**Consultation Response from KC,
Highways Development Management**
2025/93514 land at, Brownhill Farm, Old Lane, Birkenshaw, BD11 2JL
Demolition of existing barns and erection of 4 detached dwellings
Date Responded: 04/08/2026
Responding Officer: D. Stainsby
Responding Ref: K8-11SE/19

This application seeks approval to the demolition of existing barns and erection of four detached dwellings with refuse vehicle turning space and off-street parking at Brownhill Farm, Old Lane, Birkenshaw.

Project	Proposed residential development at Brown Hill Farm, Old Lane, Birkenshaw BD11 2JL	
Client	Broadleaf Properties Management Ltd, 21 Clare Road Halifax West Yorkshire HX1 2HX	
Dwg Title	(25419)6_Site Elevations	A
Scale	1:100 @ A1	
Date	Aug 25

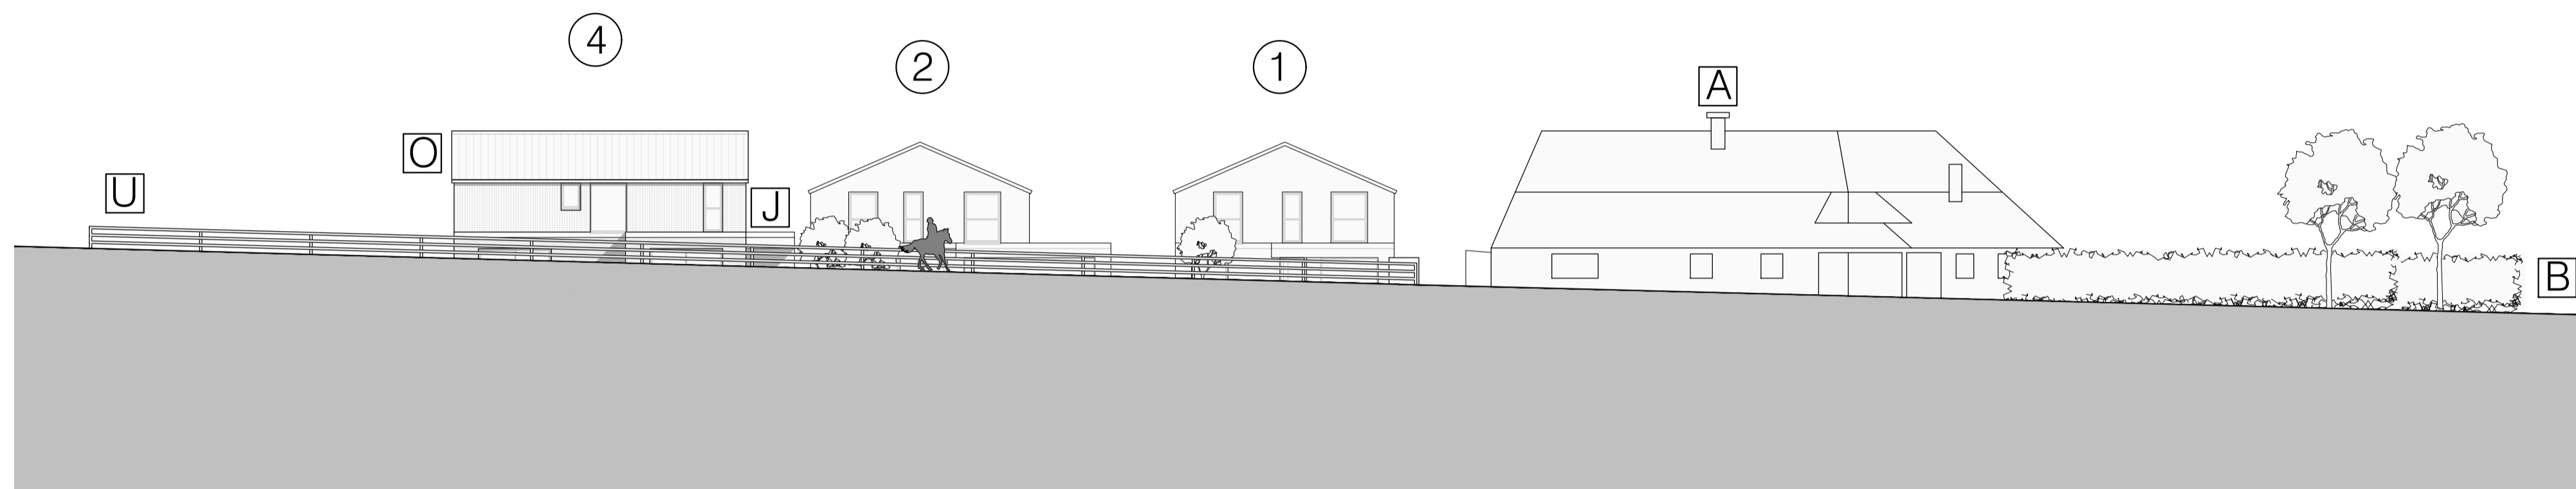
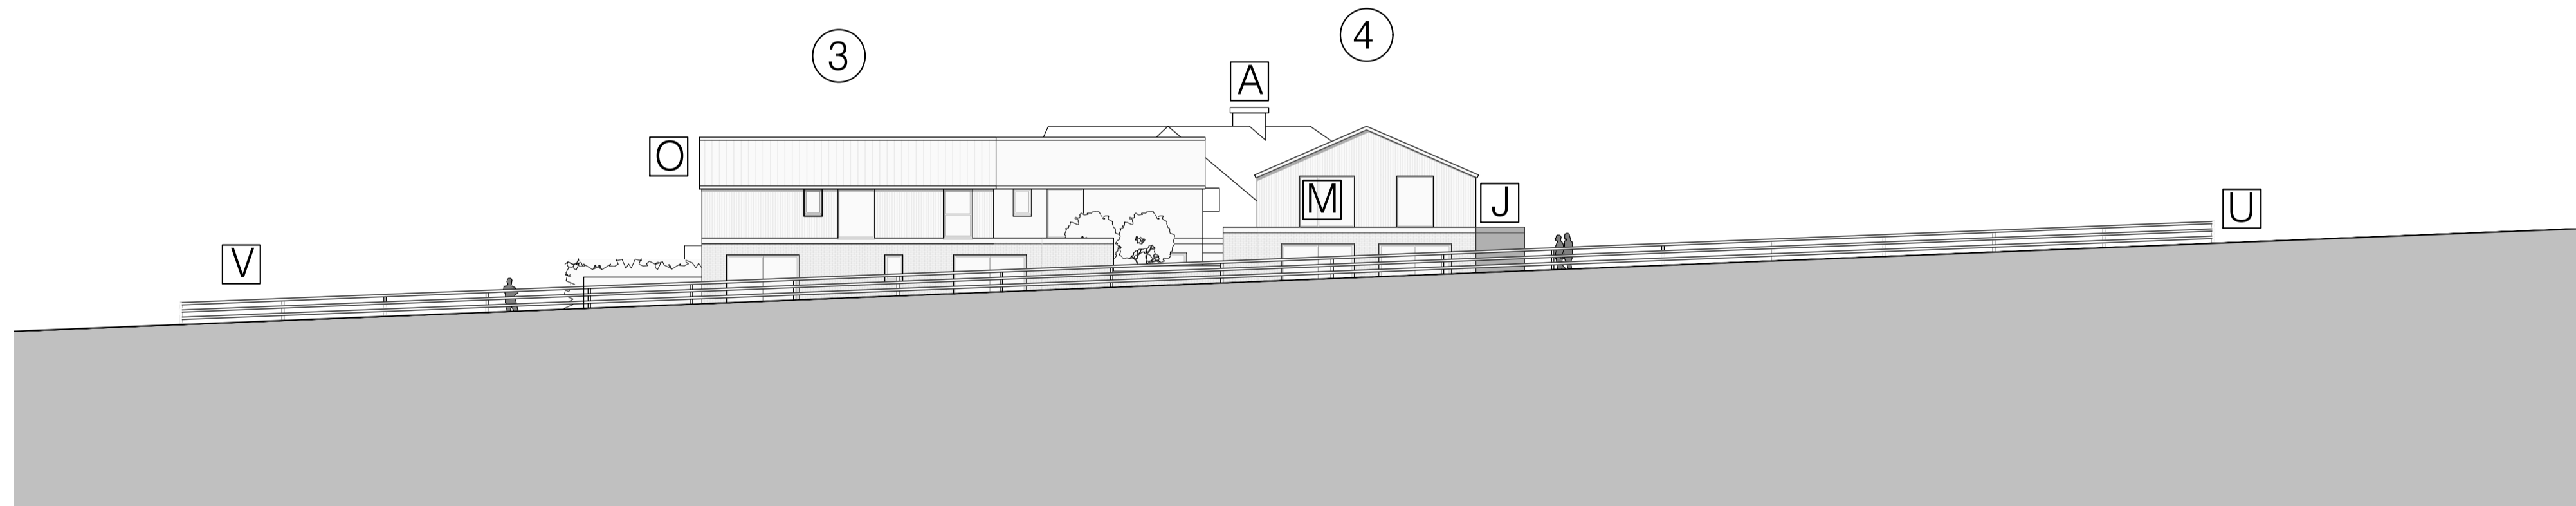
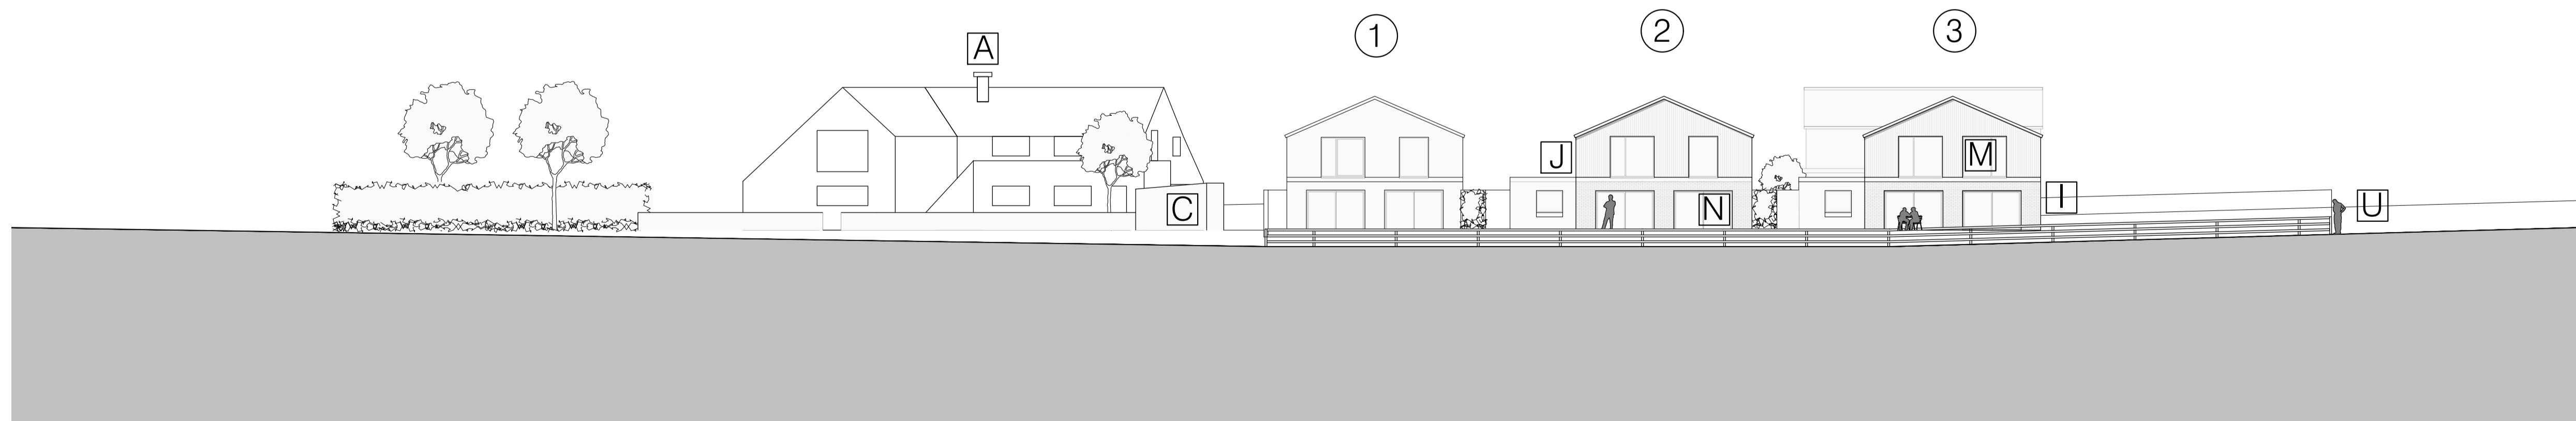
The Site Plan shows 4 detached houses sited around a refuse vehicle turning area. Each of the proposed dwellings is shown to have 2 off-street parking spaces with single integral garages.

Given the previous approval Highways Development Management have no objection to this proposal providing the access improvements are conditioned like the previous approval.

Notwithstanding the details shown on the approved plan, the development shall not commence until a scheme detailing the provision of a footway to link between the existing lengths of footway at 128 Old Lane to the south and 136 Old Lane to the north, access improvements including widening, provision of a passing bay and bus stop clearway on Old Lane to the site frontage, construction specification, surfacing, drainage and kerbing, any necessary Transport Regulation Orders and associated highway works together with independent road safety audits covering all aspects of the work has been submitted and approved in writing by the Local Planning Authority. The development shall not be brought into use until the approved scheme has been implemented and thereafter retained throughout the lifetime of the development. Reason: In the interests of highway safety and to achieve a satisfactory layout, in accordance with Policy LP21 of the Kirklees Local Plan.
